Engineers Comments Regarding Surface Water Drainage

Application Reference:	R/63/26/PL	Reviewer Reference:	ADC/EXT5/AF
Planning Officer:	Simon Brookshank	Date of Review:	29/05/2026
Site Name:	The Windmill Inn and 34 Mill Lane Rustington BN16 3JN		
Application Description:	Demolition of existing Public House and 1 No dwelling and redevelopment for retirement living accommodation comprising 28 No retirement living apartments and 3 No retirement living cottages, including communal facilities, access, car parking and landscaping (resubmission following R/143/24/PL). This application is in CIL Zone 4 (Zero Rated) as other development.		
Assessment Number:	1

**Proposed Site Layout
and Positively Drained Areas Plan**

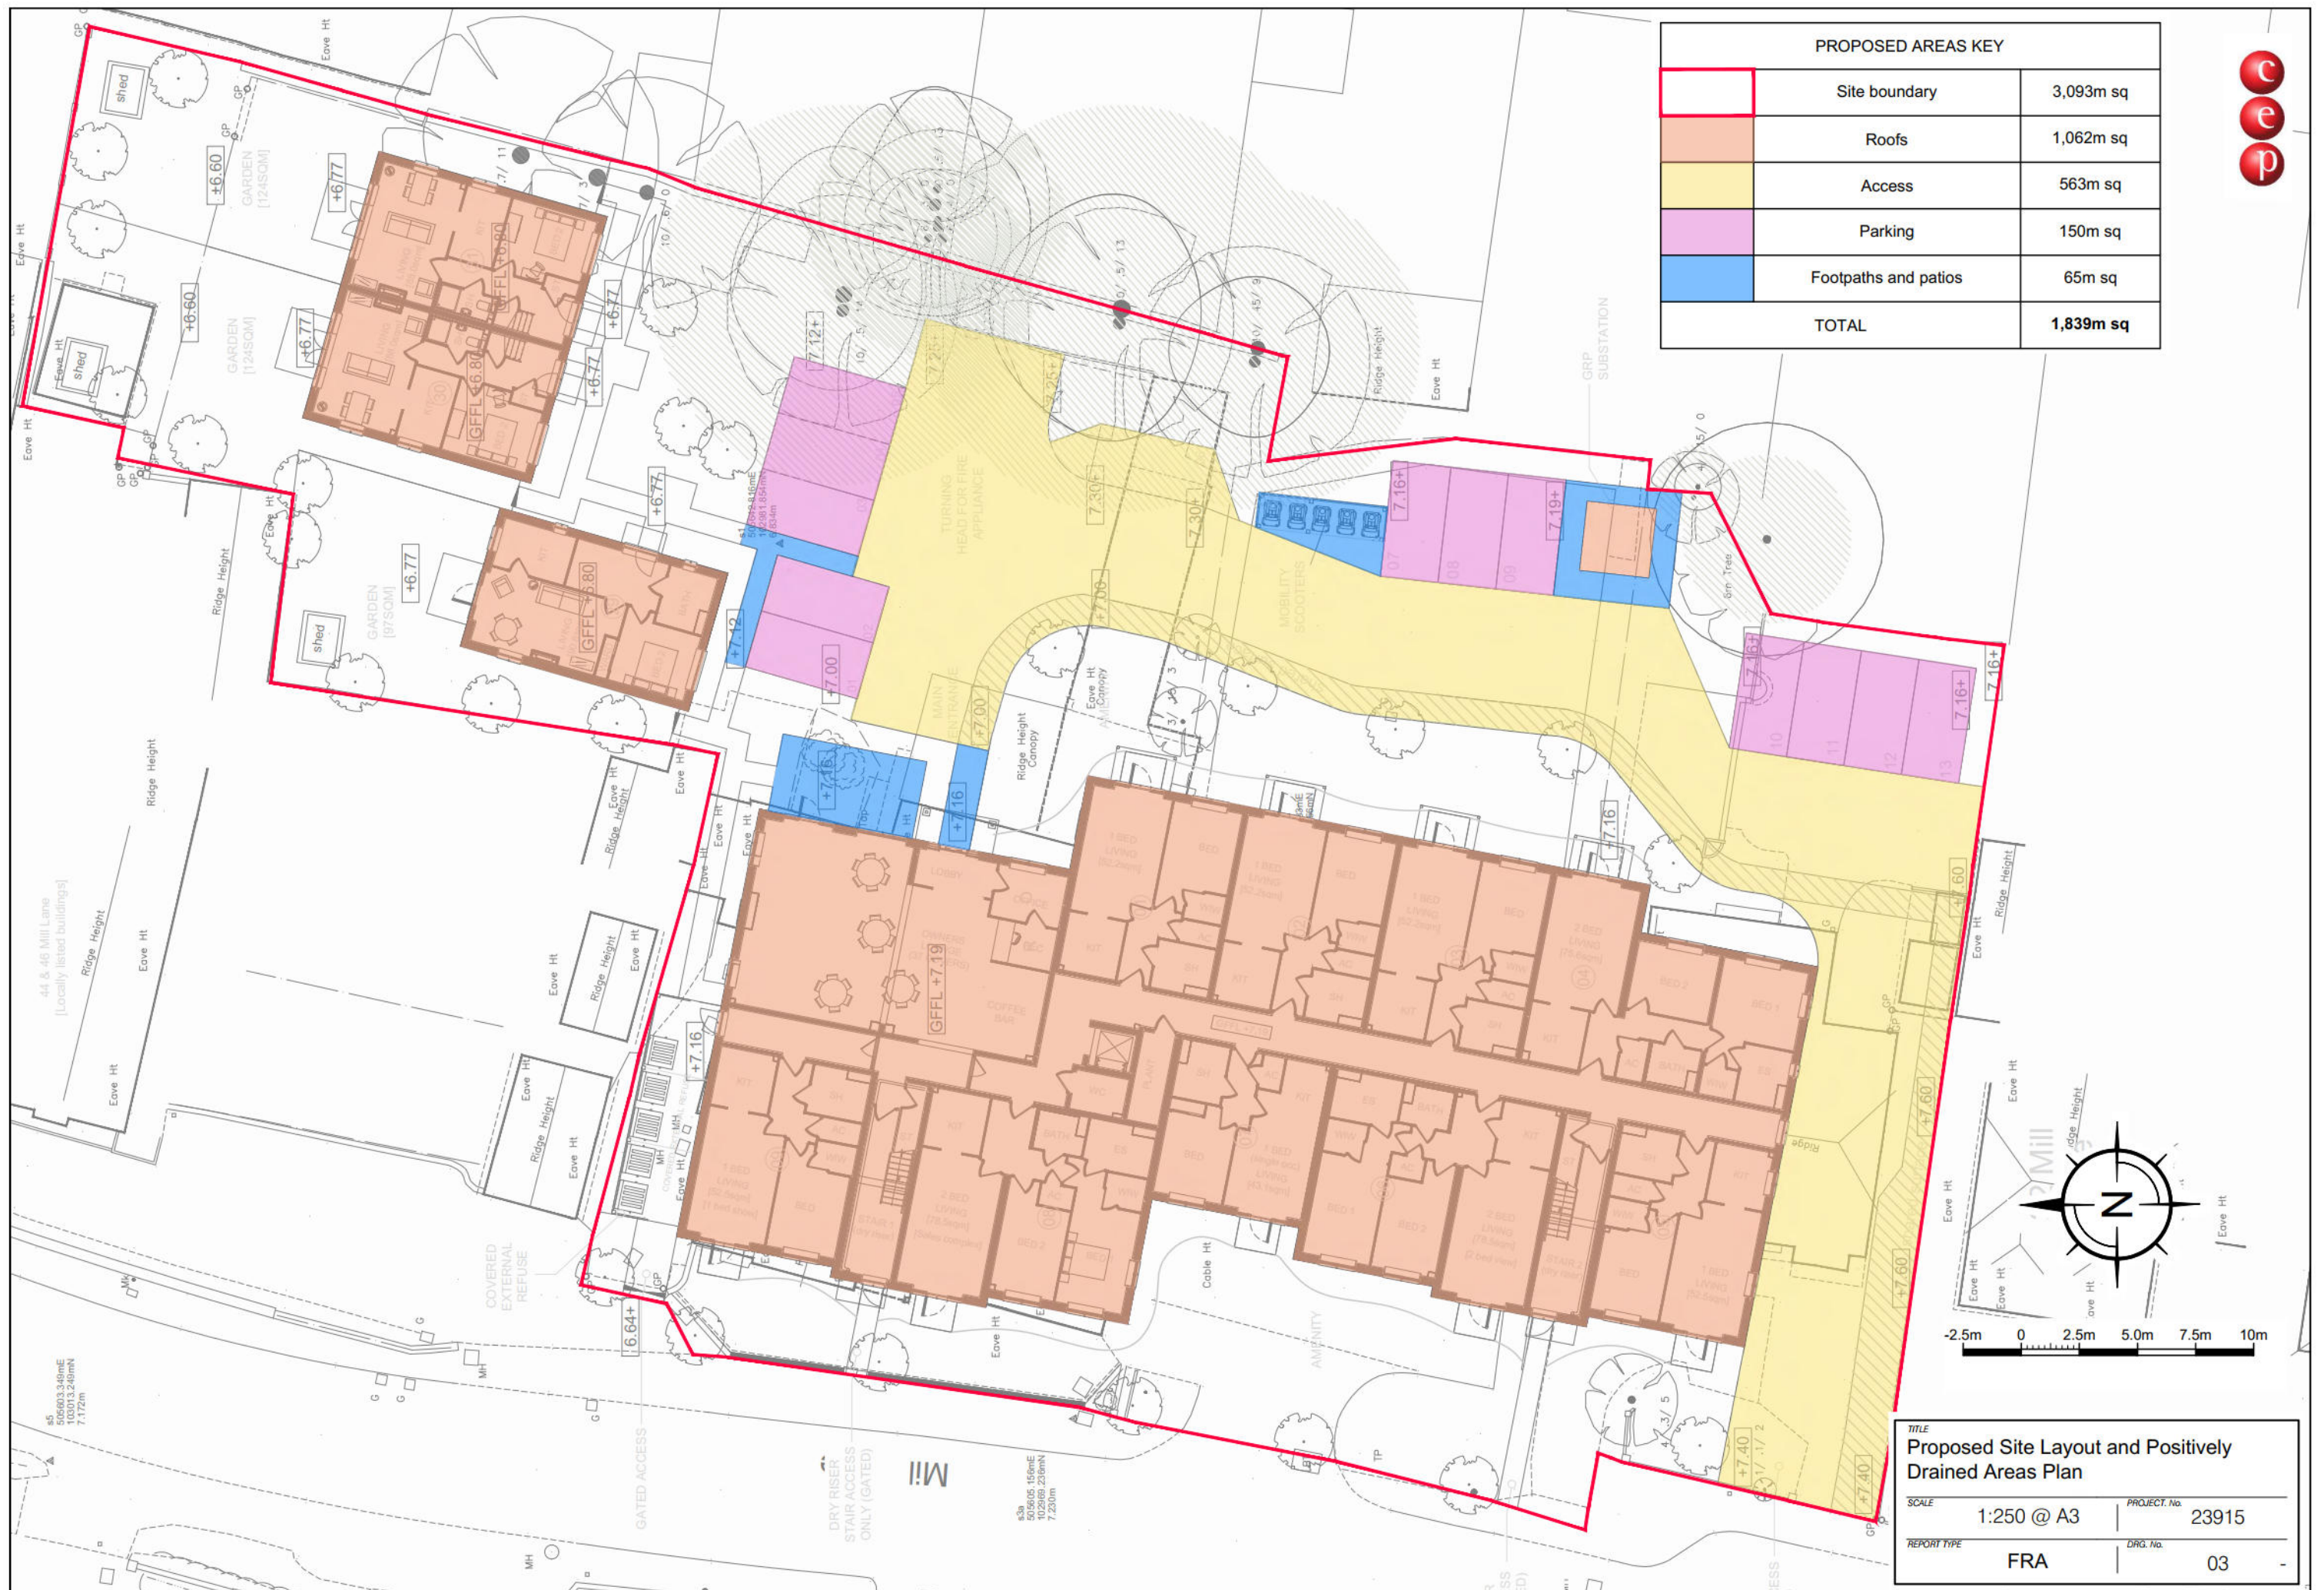
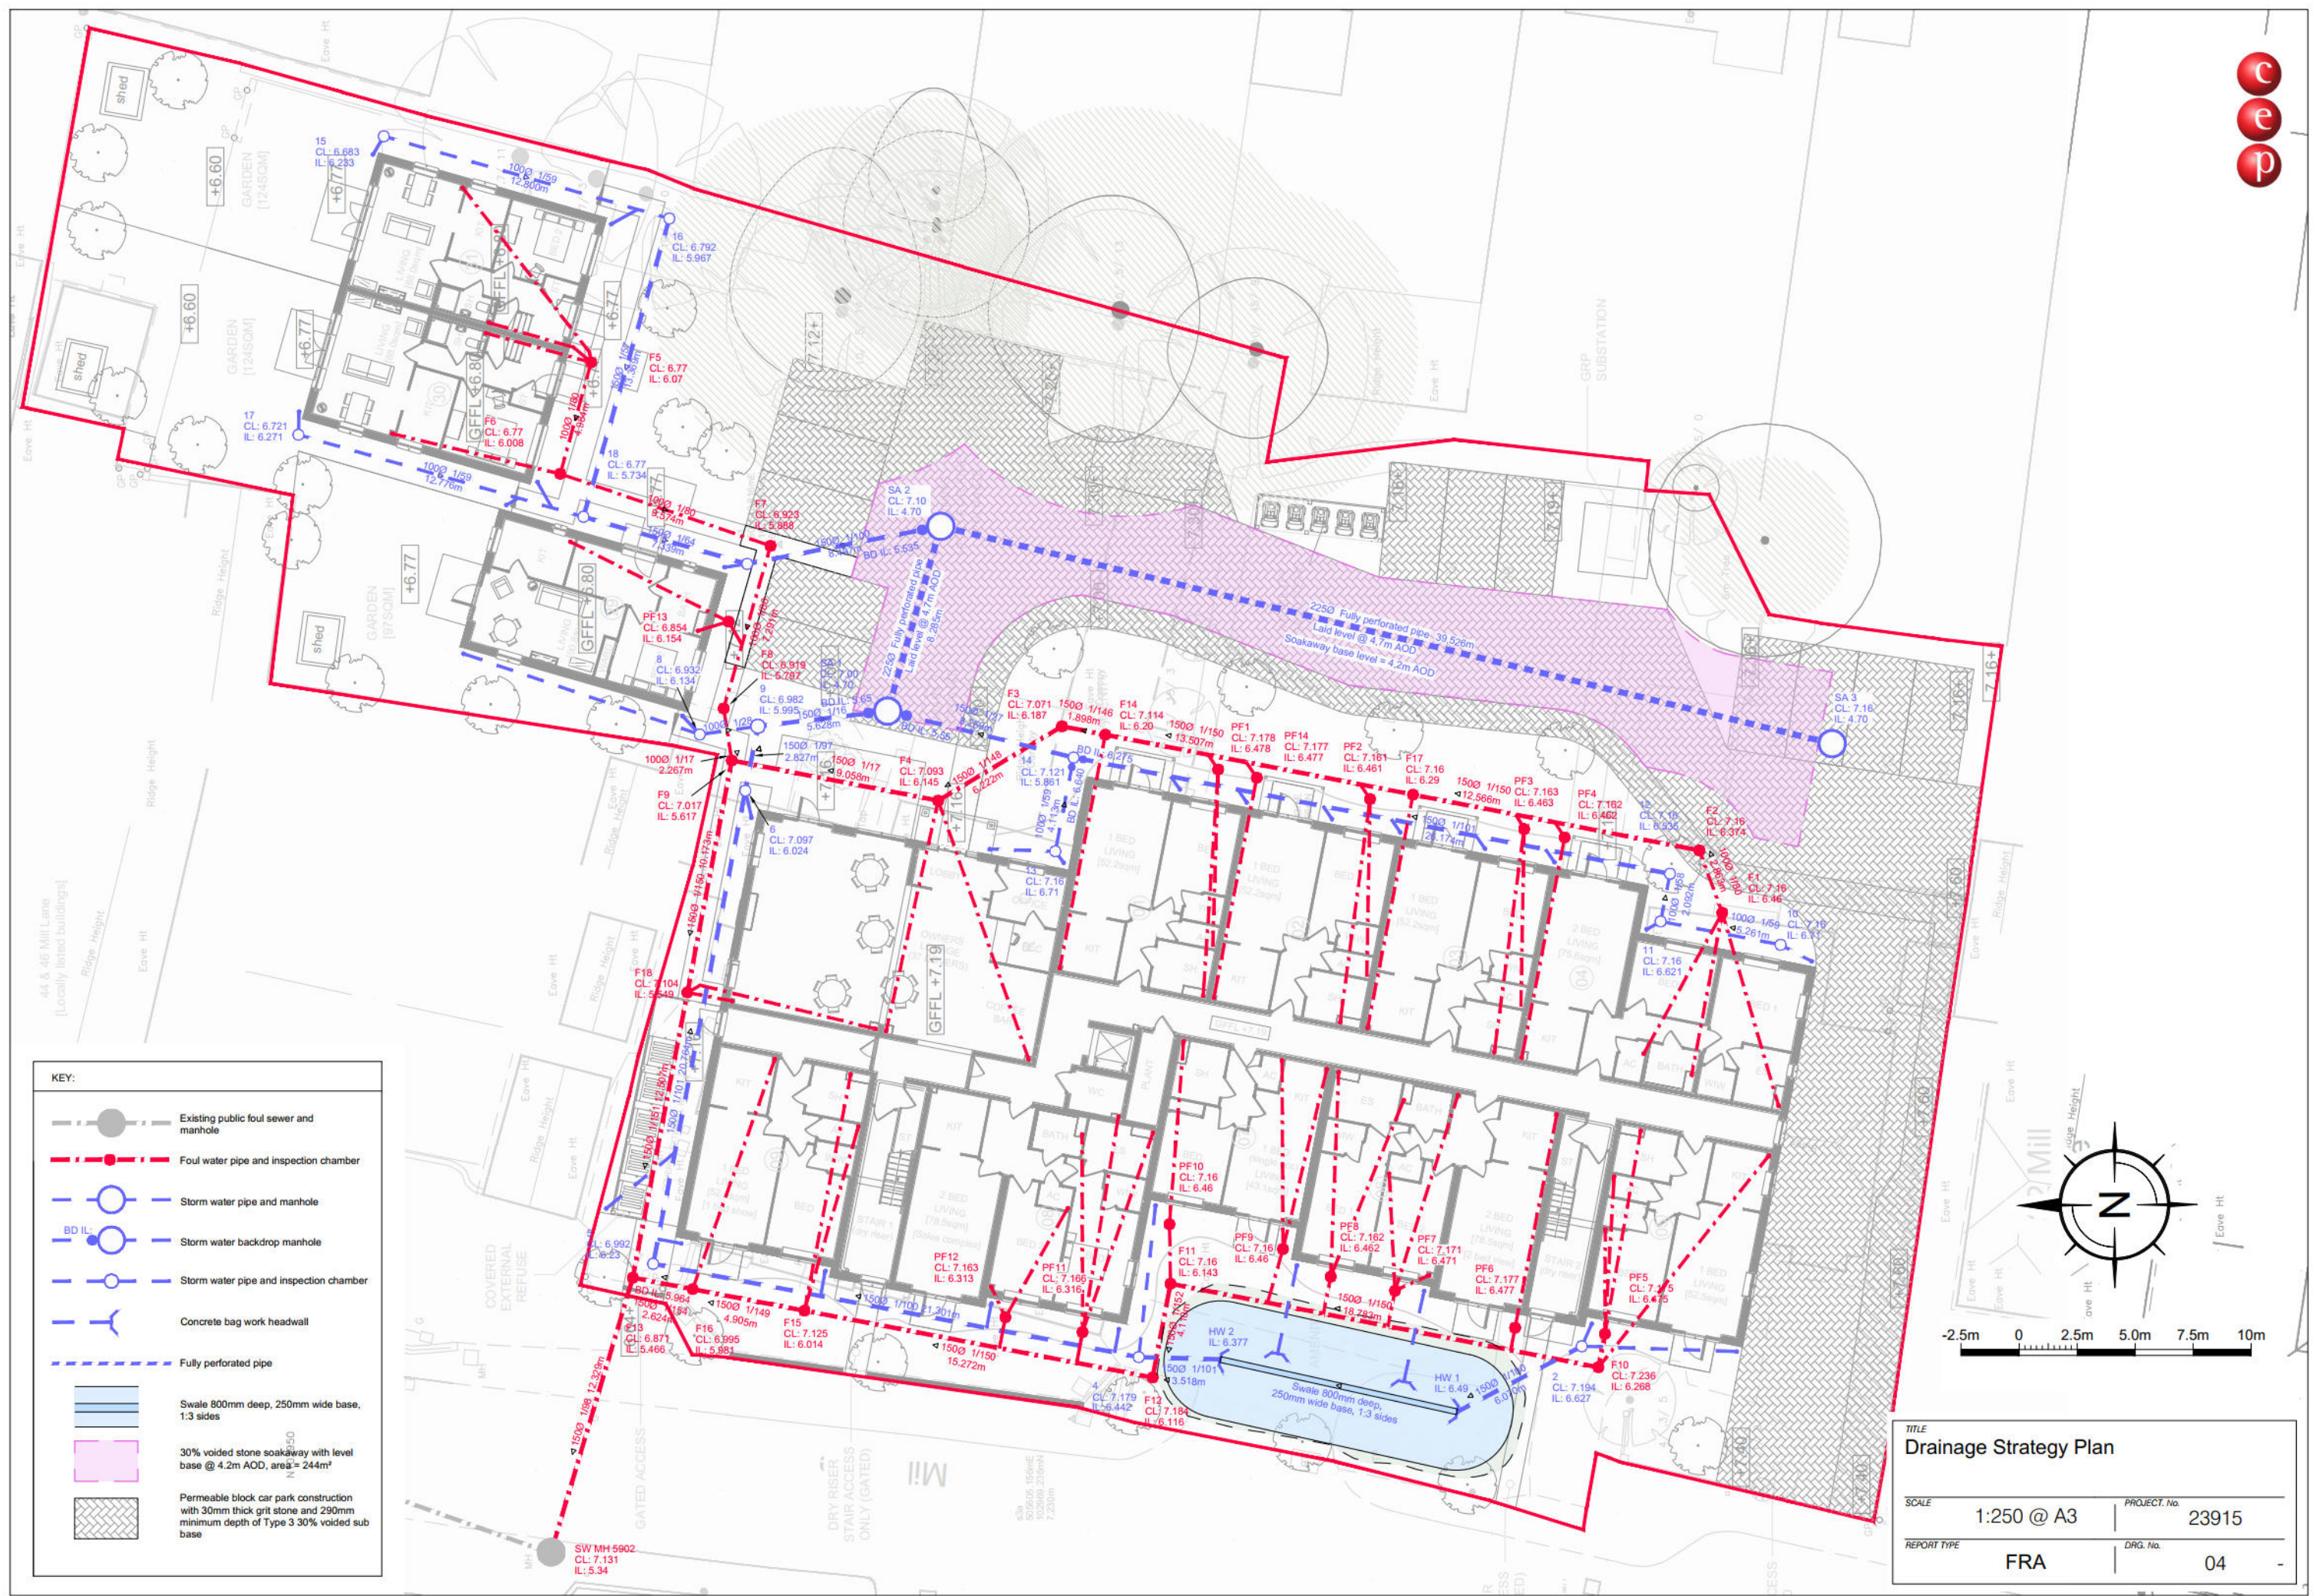
- 3.1. Calculations are provided which show the system does not flood during the design storm and that half drain times for the 3.3% AEP storm are within 24 hours.
- 3.2. Exceedance paths are currently shown through fences and/or gates adjacent to buildings which may hamper the flow. However, the use of permeable pavement reduces the risk of inlet capacity being exceeded and the low point in the drainage system is covers in the rear gardens at the northern end. The exceedance paths plan should be clarified.

Exceedance routes have been indicated and are for events in excess of the 100 year plus 45% event.
